OXFORDSHIRE COUNTY COUNCIL'S RESPONSE TO CONSULTATION ON THE FOLLOWING DEVELOPMENT PROPOSAL

Application no: 15/01267/REM

Proposal: Reserved Matters to 10/01642/OUT - 44 residential dwellings, garages, highway works, boundary treatments and associated works

Location: Parcel B6 Adj To Camp Road And Gordon Road Upper Heyford

SITE				PARCEL B6	
DRAWING TITLE				UPPER HEYFORD	
PLOTS 170 - 178 & 270 - 291				STREET SCENES 1 OF 2	
DRAWN BY	DATE	CHECKED/DATE	DRAWING NO.	REV	
CW	JULY 15		UPP/02/222	B	
SCALE	1:200 A1

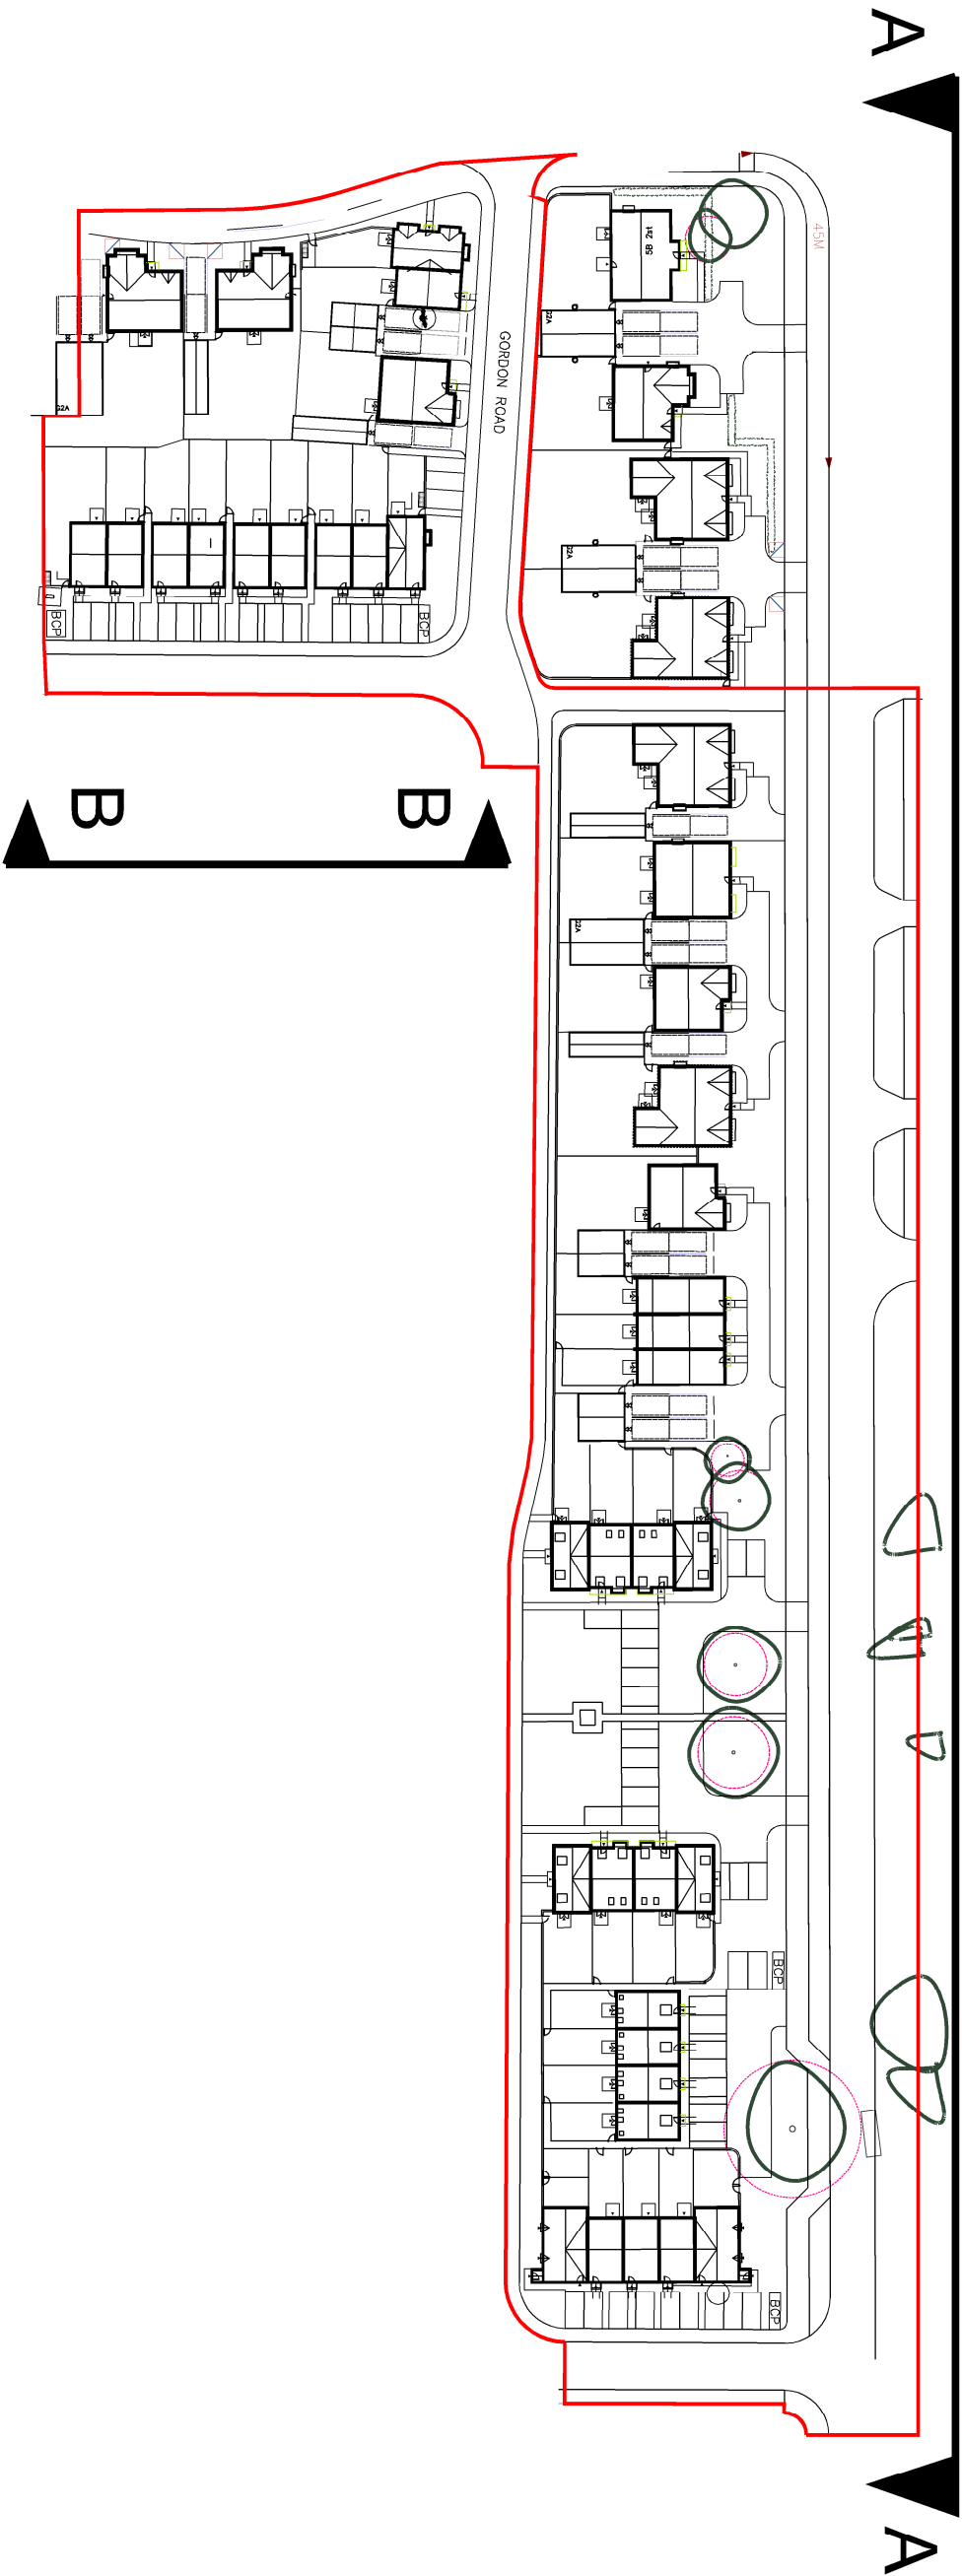
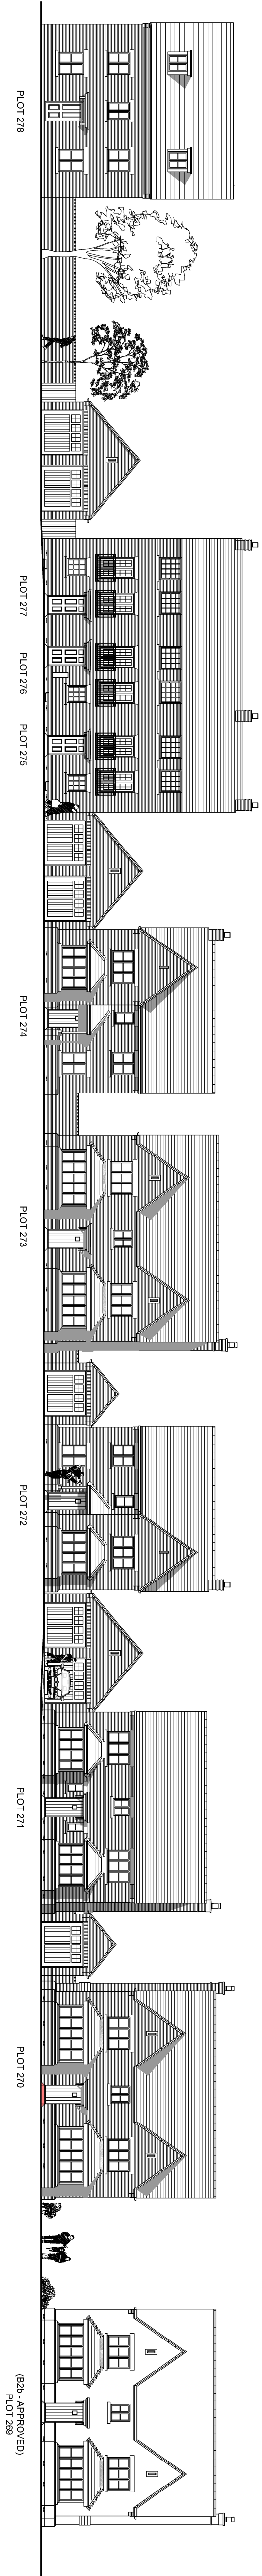
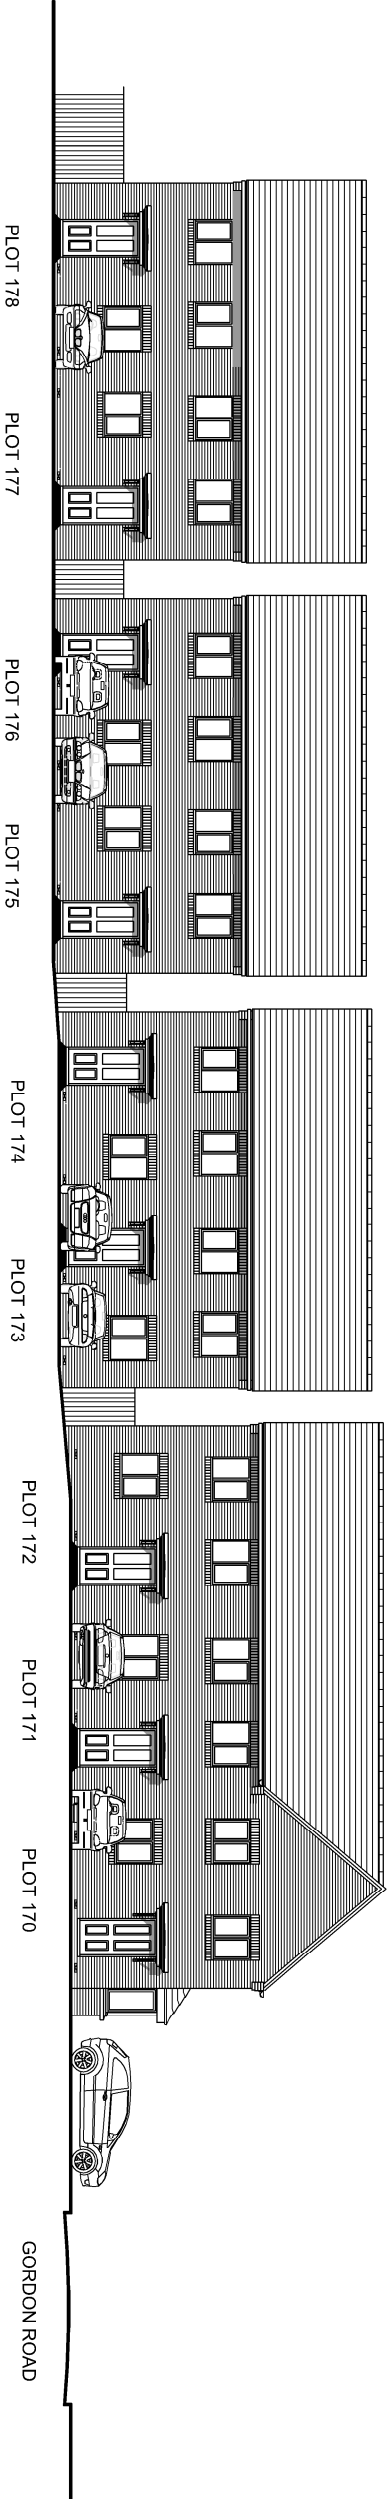
There are several accesses directly onto Camp Road, but nowhere in the application are visibility splays demonstrated for these accesses. Visibility splays for each access will be required to be demonstrated in accordance with the Manual for Streets.

The accesses to plots 278 to 289 do not appear to show crossovers of the pedestrian footway. This will need to be demonstrated.
